**CITY OF ALBUQUERQUE
ADMINISTRATIVE APPROVAL (AA)-
SITE DEVELOPMENT PLAN AMENDMENT TRACKING SHEET**

APPLICATION #: 17AA-10131	PROJECT #: 1011456
PROJECT NAME: CRUNCH GYM @ MANZANO SHOPPING CTR	
ADDRESS: LOMAS + JUAN TABO	
APPLICANT or AGENT: DAC · ROBERT ROMERO	
PHONE #: 247-4530	EMAIL: r.romero505@gmail.com
ZONE ATLAS PAGE:	
ADMINISTRATIVE APPROVAL (AA) for:	<input type="checkbox"/> EPC CASE <input type="checkbox"/> DRB CASE

Administrative Amendment Request

Project #1011456 17-AA-10131

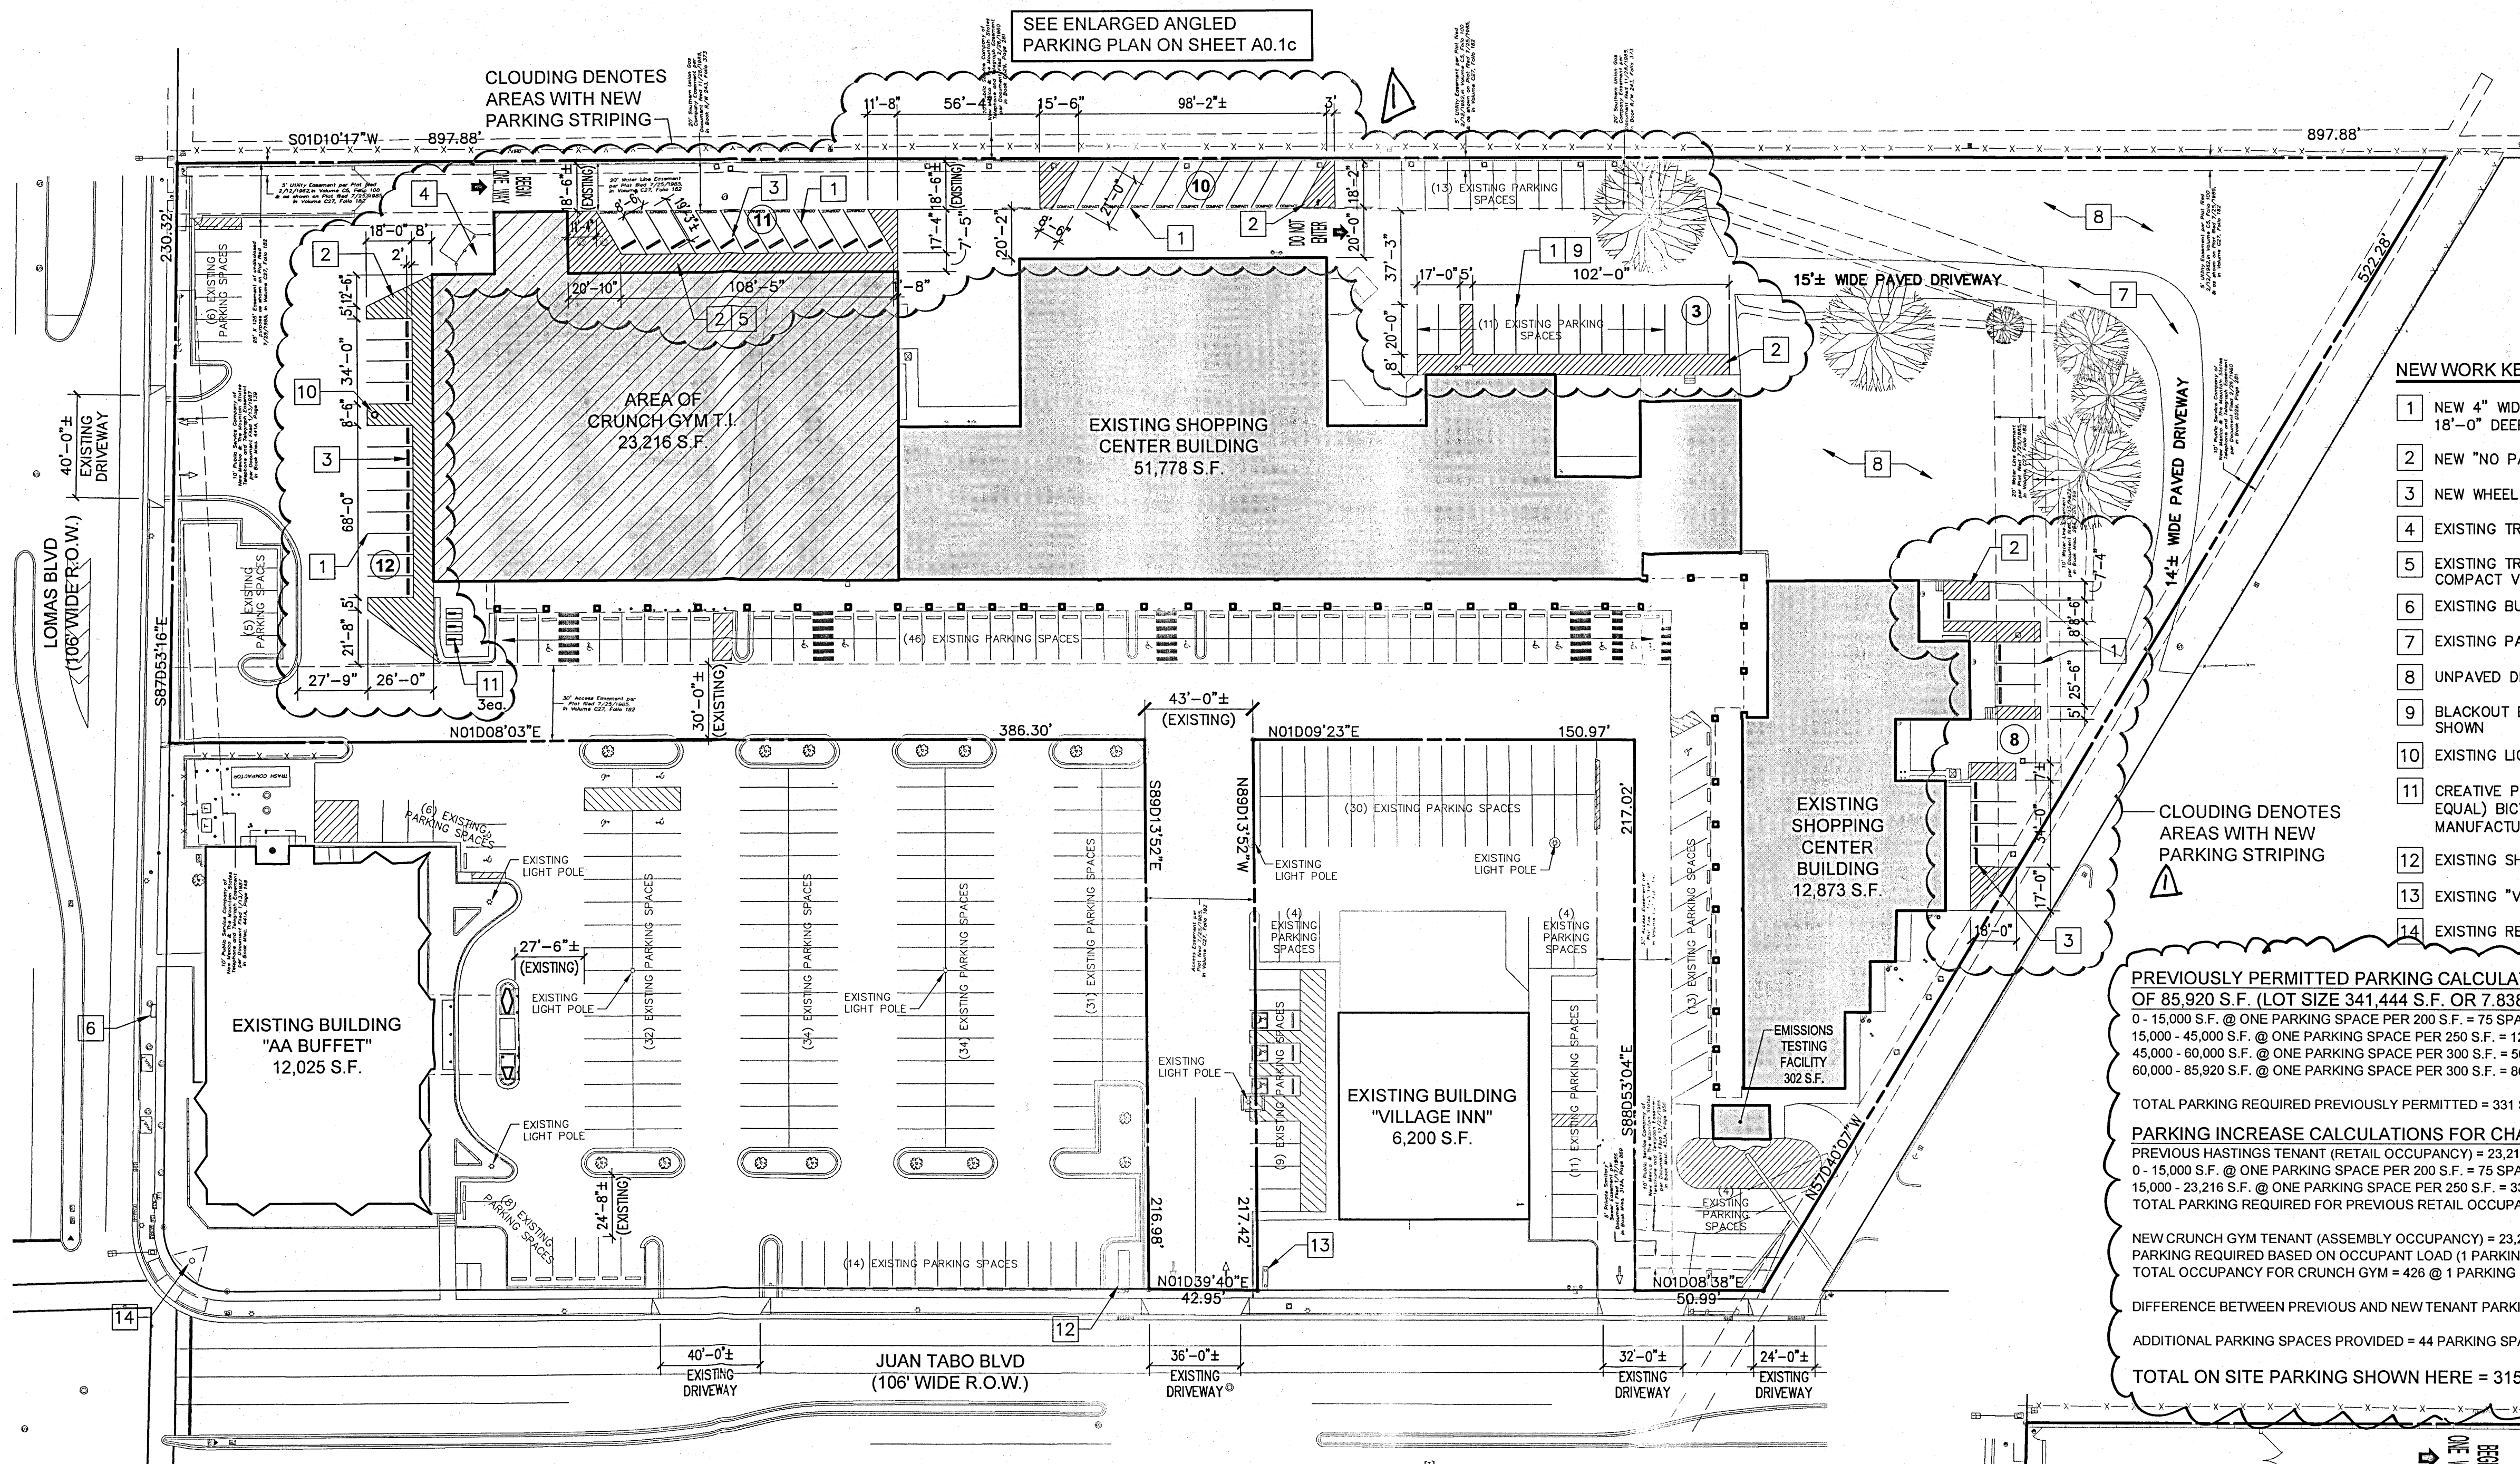
4. Dimension the widths of the alley and the paved driveway in the back.
5. Parking ADA signs and striping should be refreshed and updated to current standards.

ENLARGED ANGLED PARKING

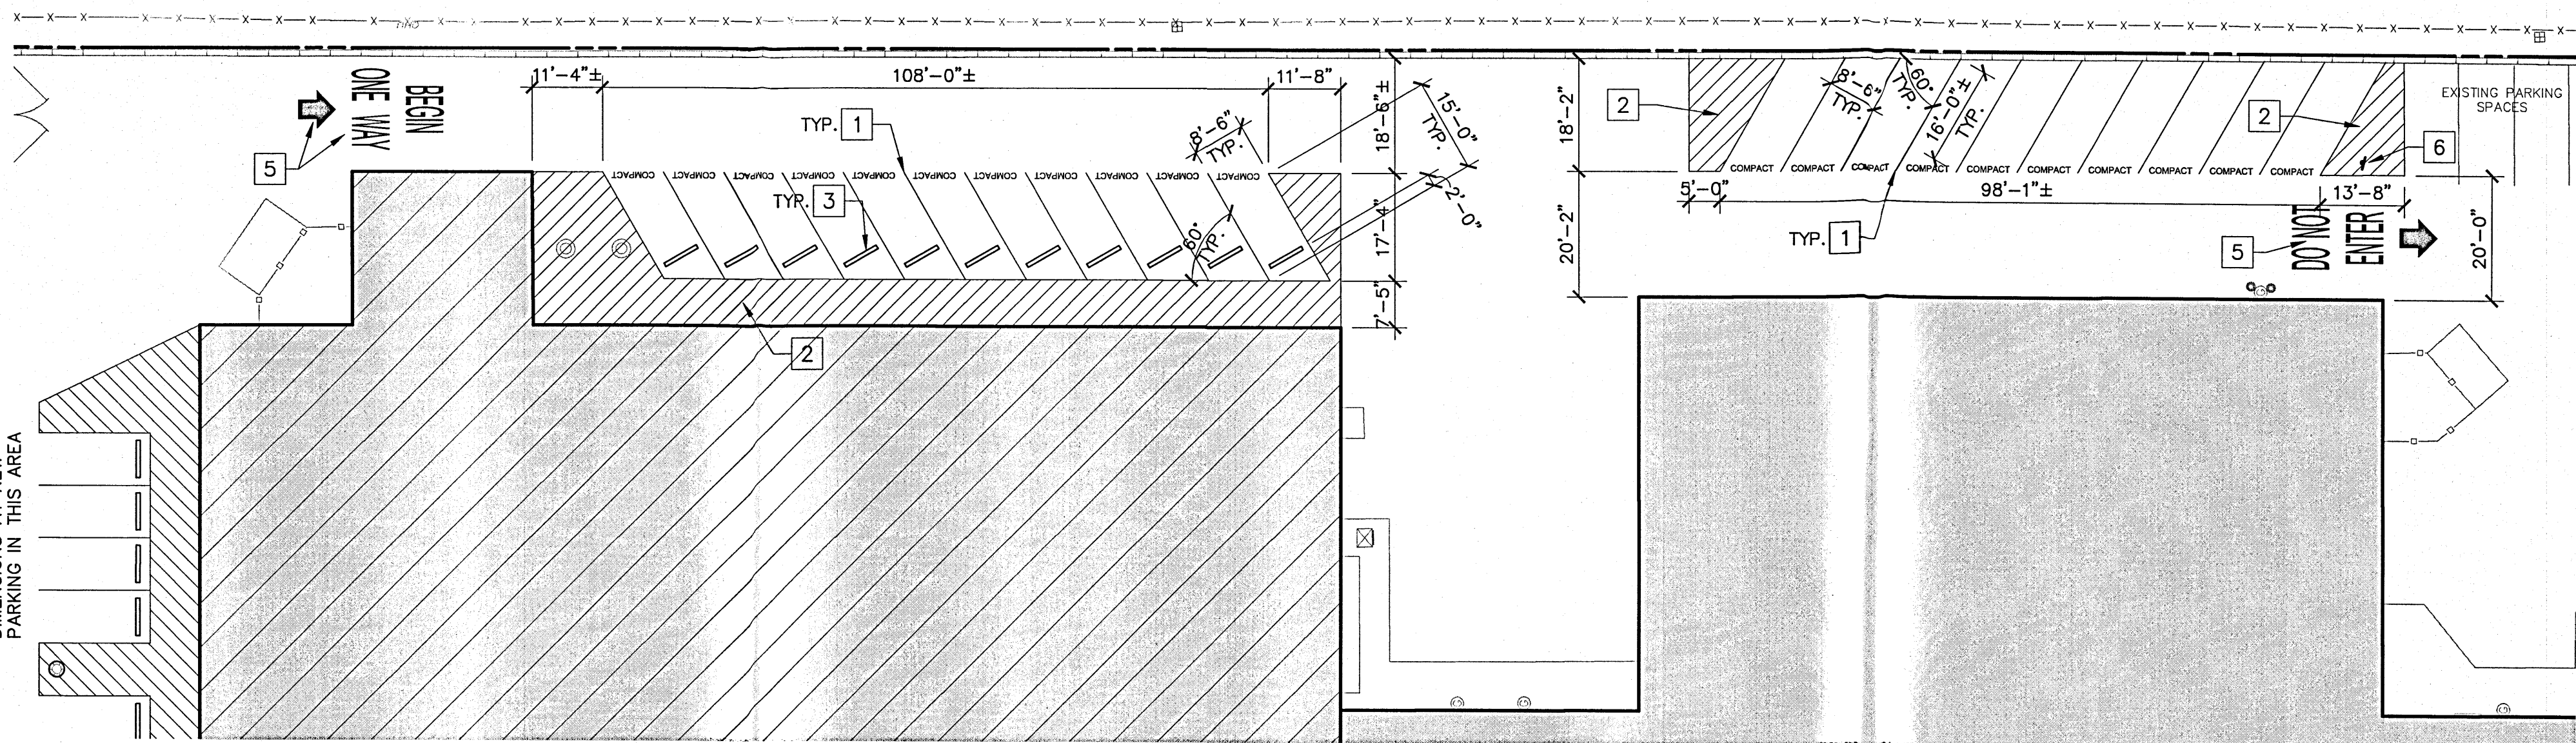
1. Angled parking must contain the full length and width of a parking space. Please provide the angle of the angled parking.

① HANDICAP SIGNAGE
NO SCALE

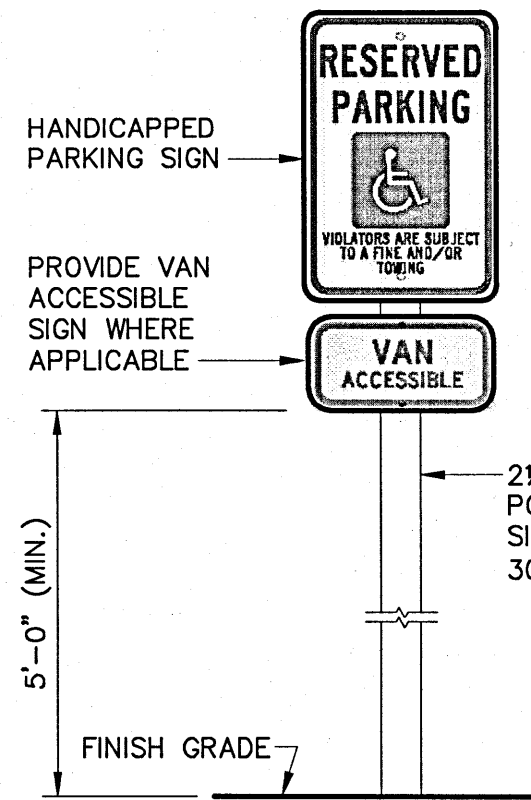
6. The ADA accessible parking sign must have the required language per 66-7-352.4C NMSA 1978 **"Violators Are Subject to a Fine and/or Towing."** Please call out detail and location of HC signs.

② DIRECTIONAL SIGNAGE
NO SCALE

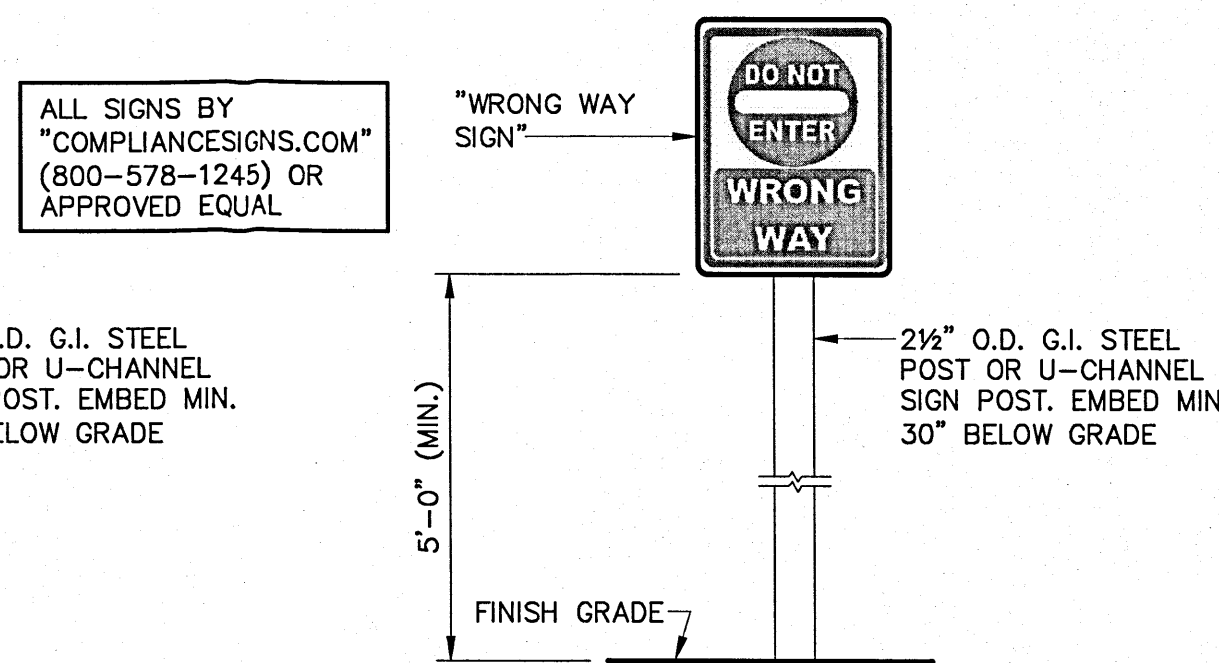
2. Label the compact parking spaces by placing the words **"COMPACT"** on the pavement of each space.
3. One-way vehicular paths require pavement directional signage and a posted **"Do Not Enter"** sign at the point of egress. Please show detail and location of posted signs.

③ TYPICAL HANDICAPPED PARKING
SCALE: 1" = 10'-0"

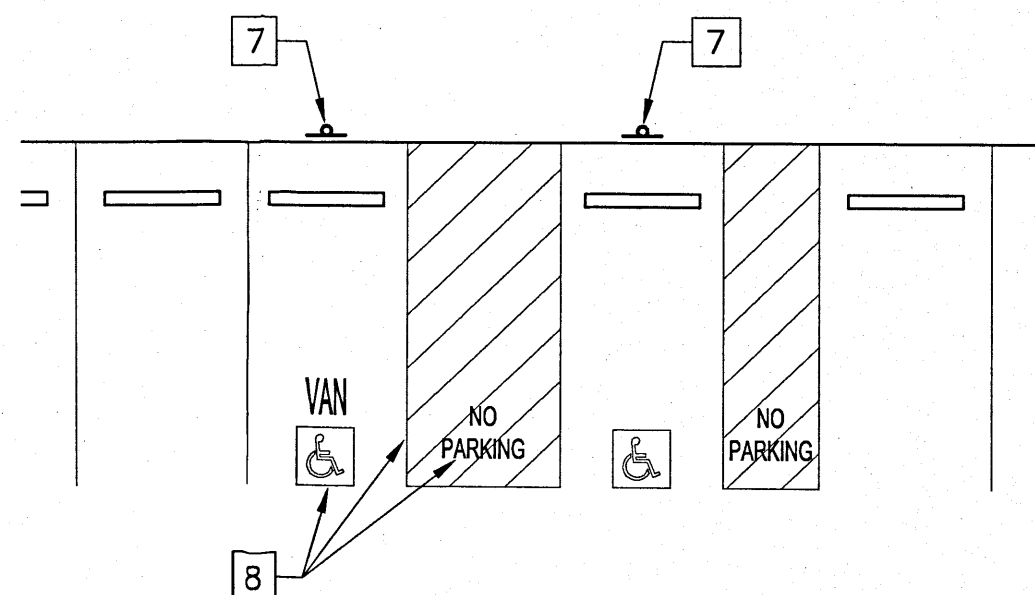
7. The ADA access aisles shall have the words **"NO PARKING"** in capital letters, each of which shall be at least one foot high and at least two inches wide, placed at the rear of the parking space so as to be close to where an adjacent vehicle's rear tire would be placed. (66-1-4.1.B NMSA 1978)
